Your Ref: OWQC19806
Our Ref: BR/176/18/PL
Please ask for:
Mr R Castro-Parker

30th August 2018

Creation of balcony at 2nd floor level (east). Replace existing balcony balustrades at first floor level (east) - This application affects the character & appearance of The Steyne, Bognor Conservation Area
2 & 3 Langford House 7 The Steyne Bognor Regis

PROPOSED east elevation (front)

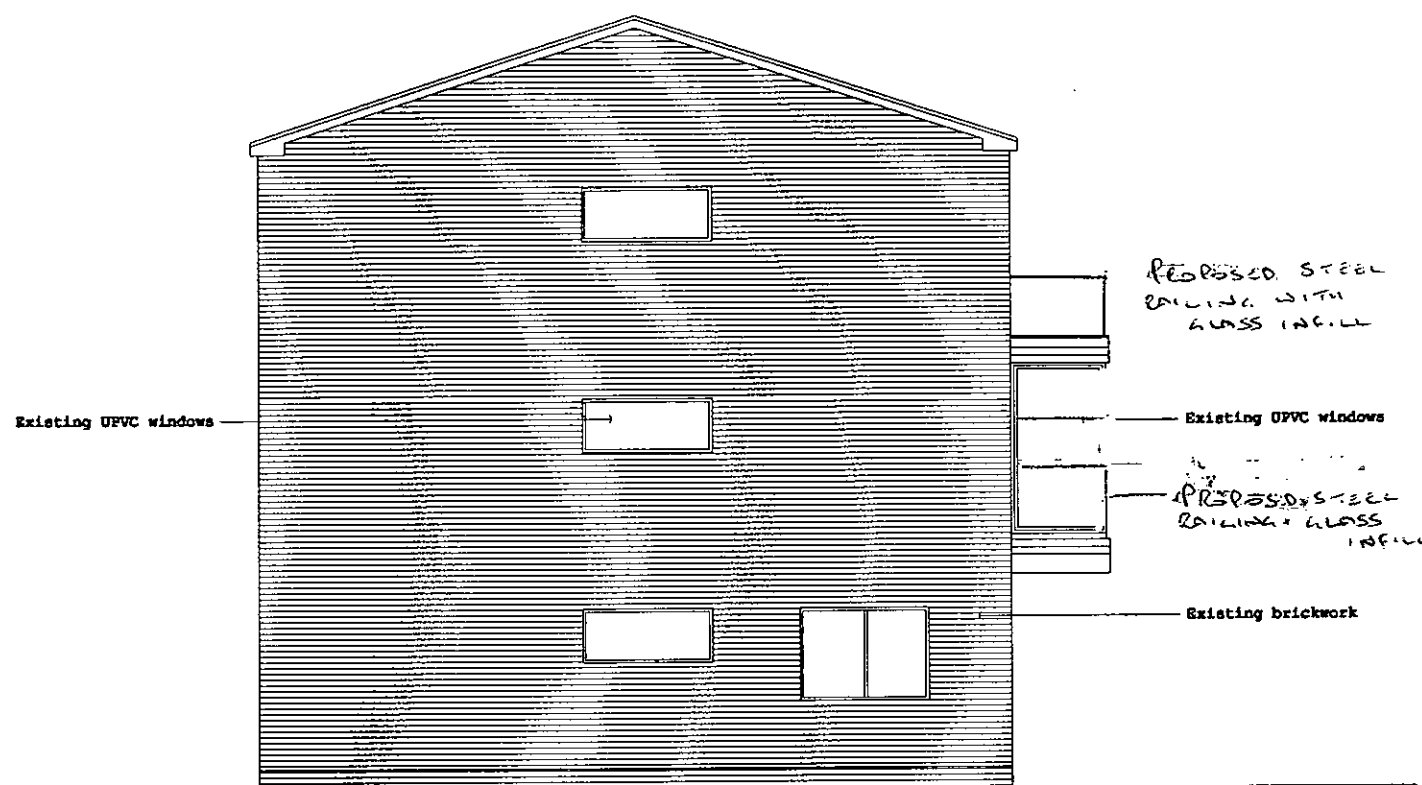
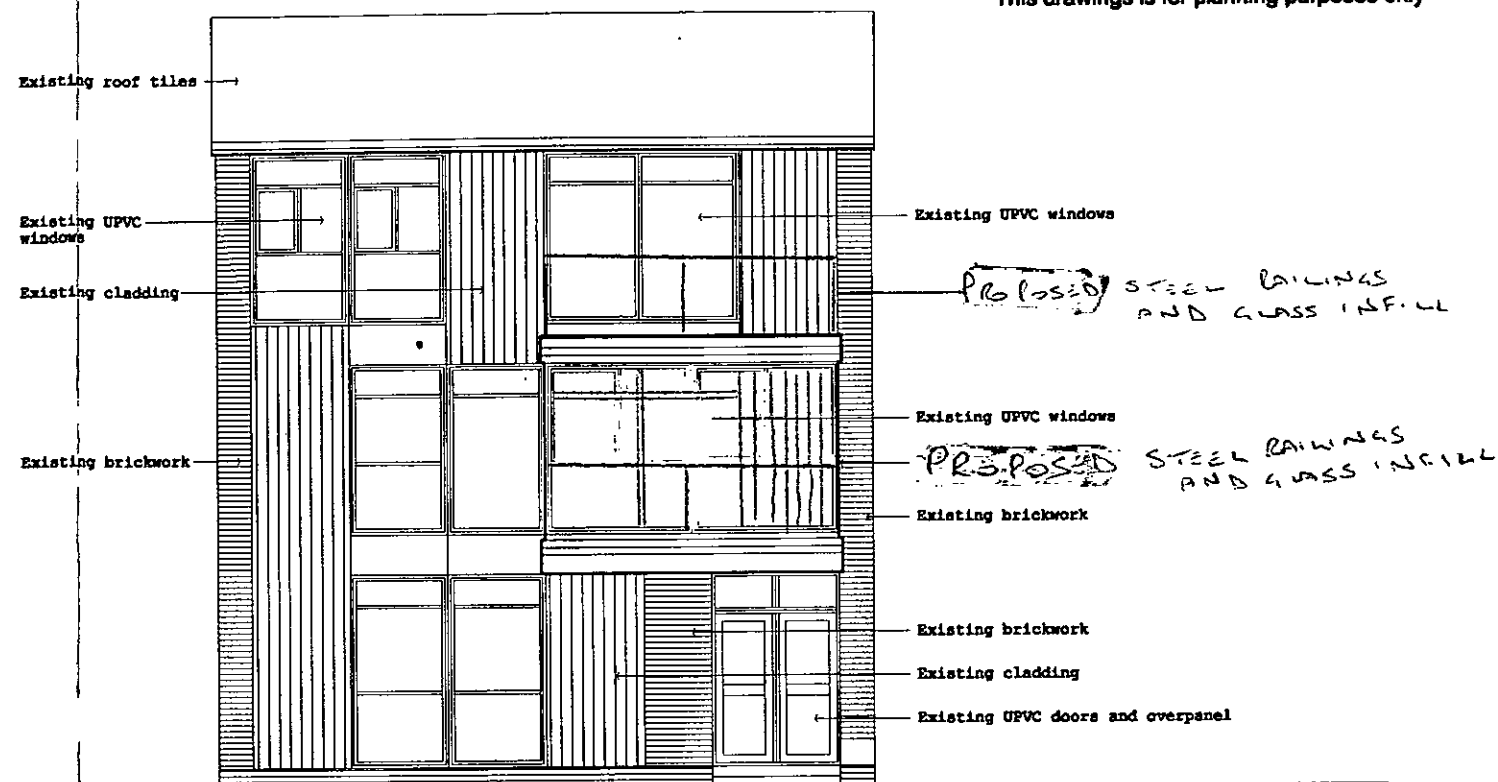
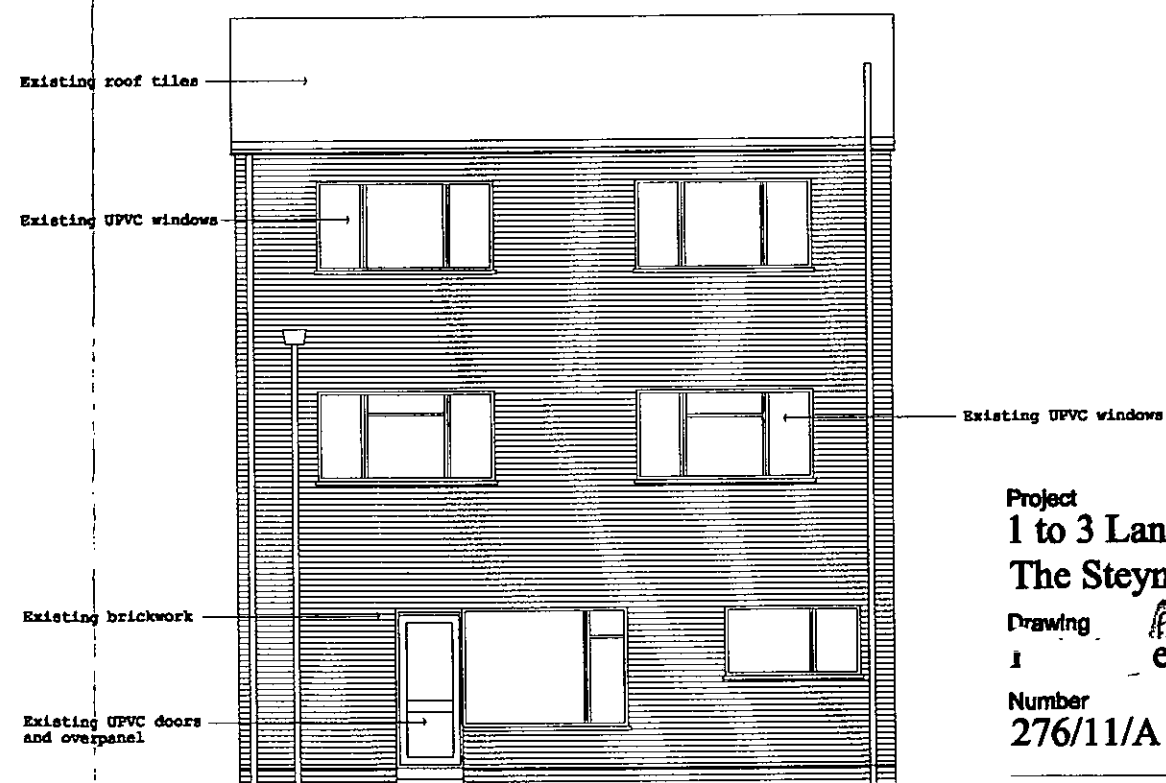
NO OBJECTION subject to Building Control approval and with a request that all metalwork for the balcony is sympathetic to the street scene and specifically the metalwork on the opposite side of The Steyne. Furthermore, as this is a Conservation Area, Members would expect a high standard of finish with full exterior decoration
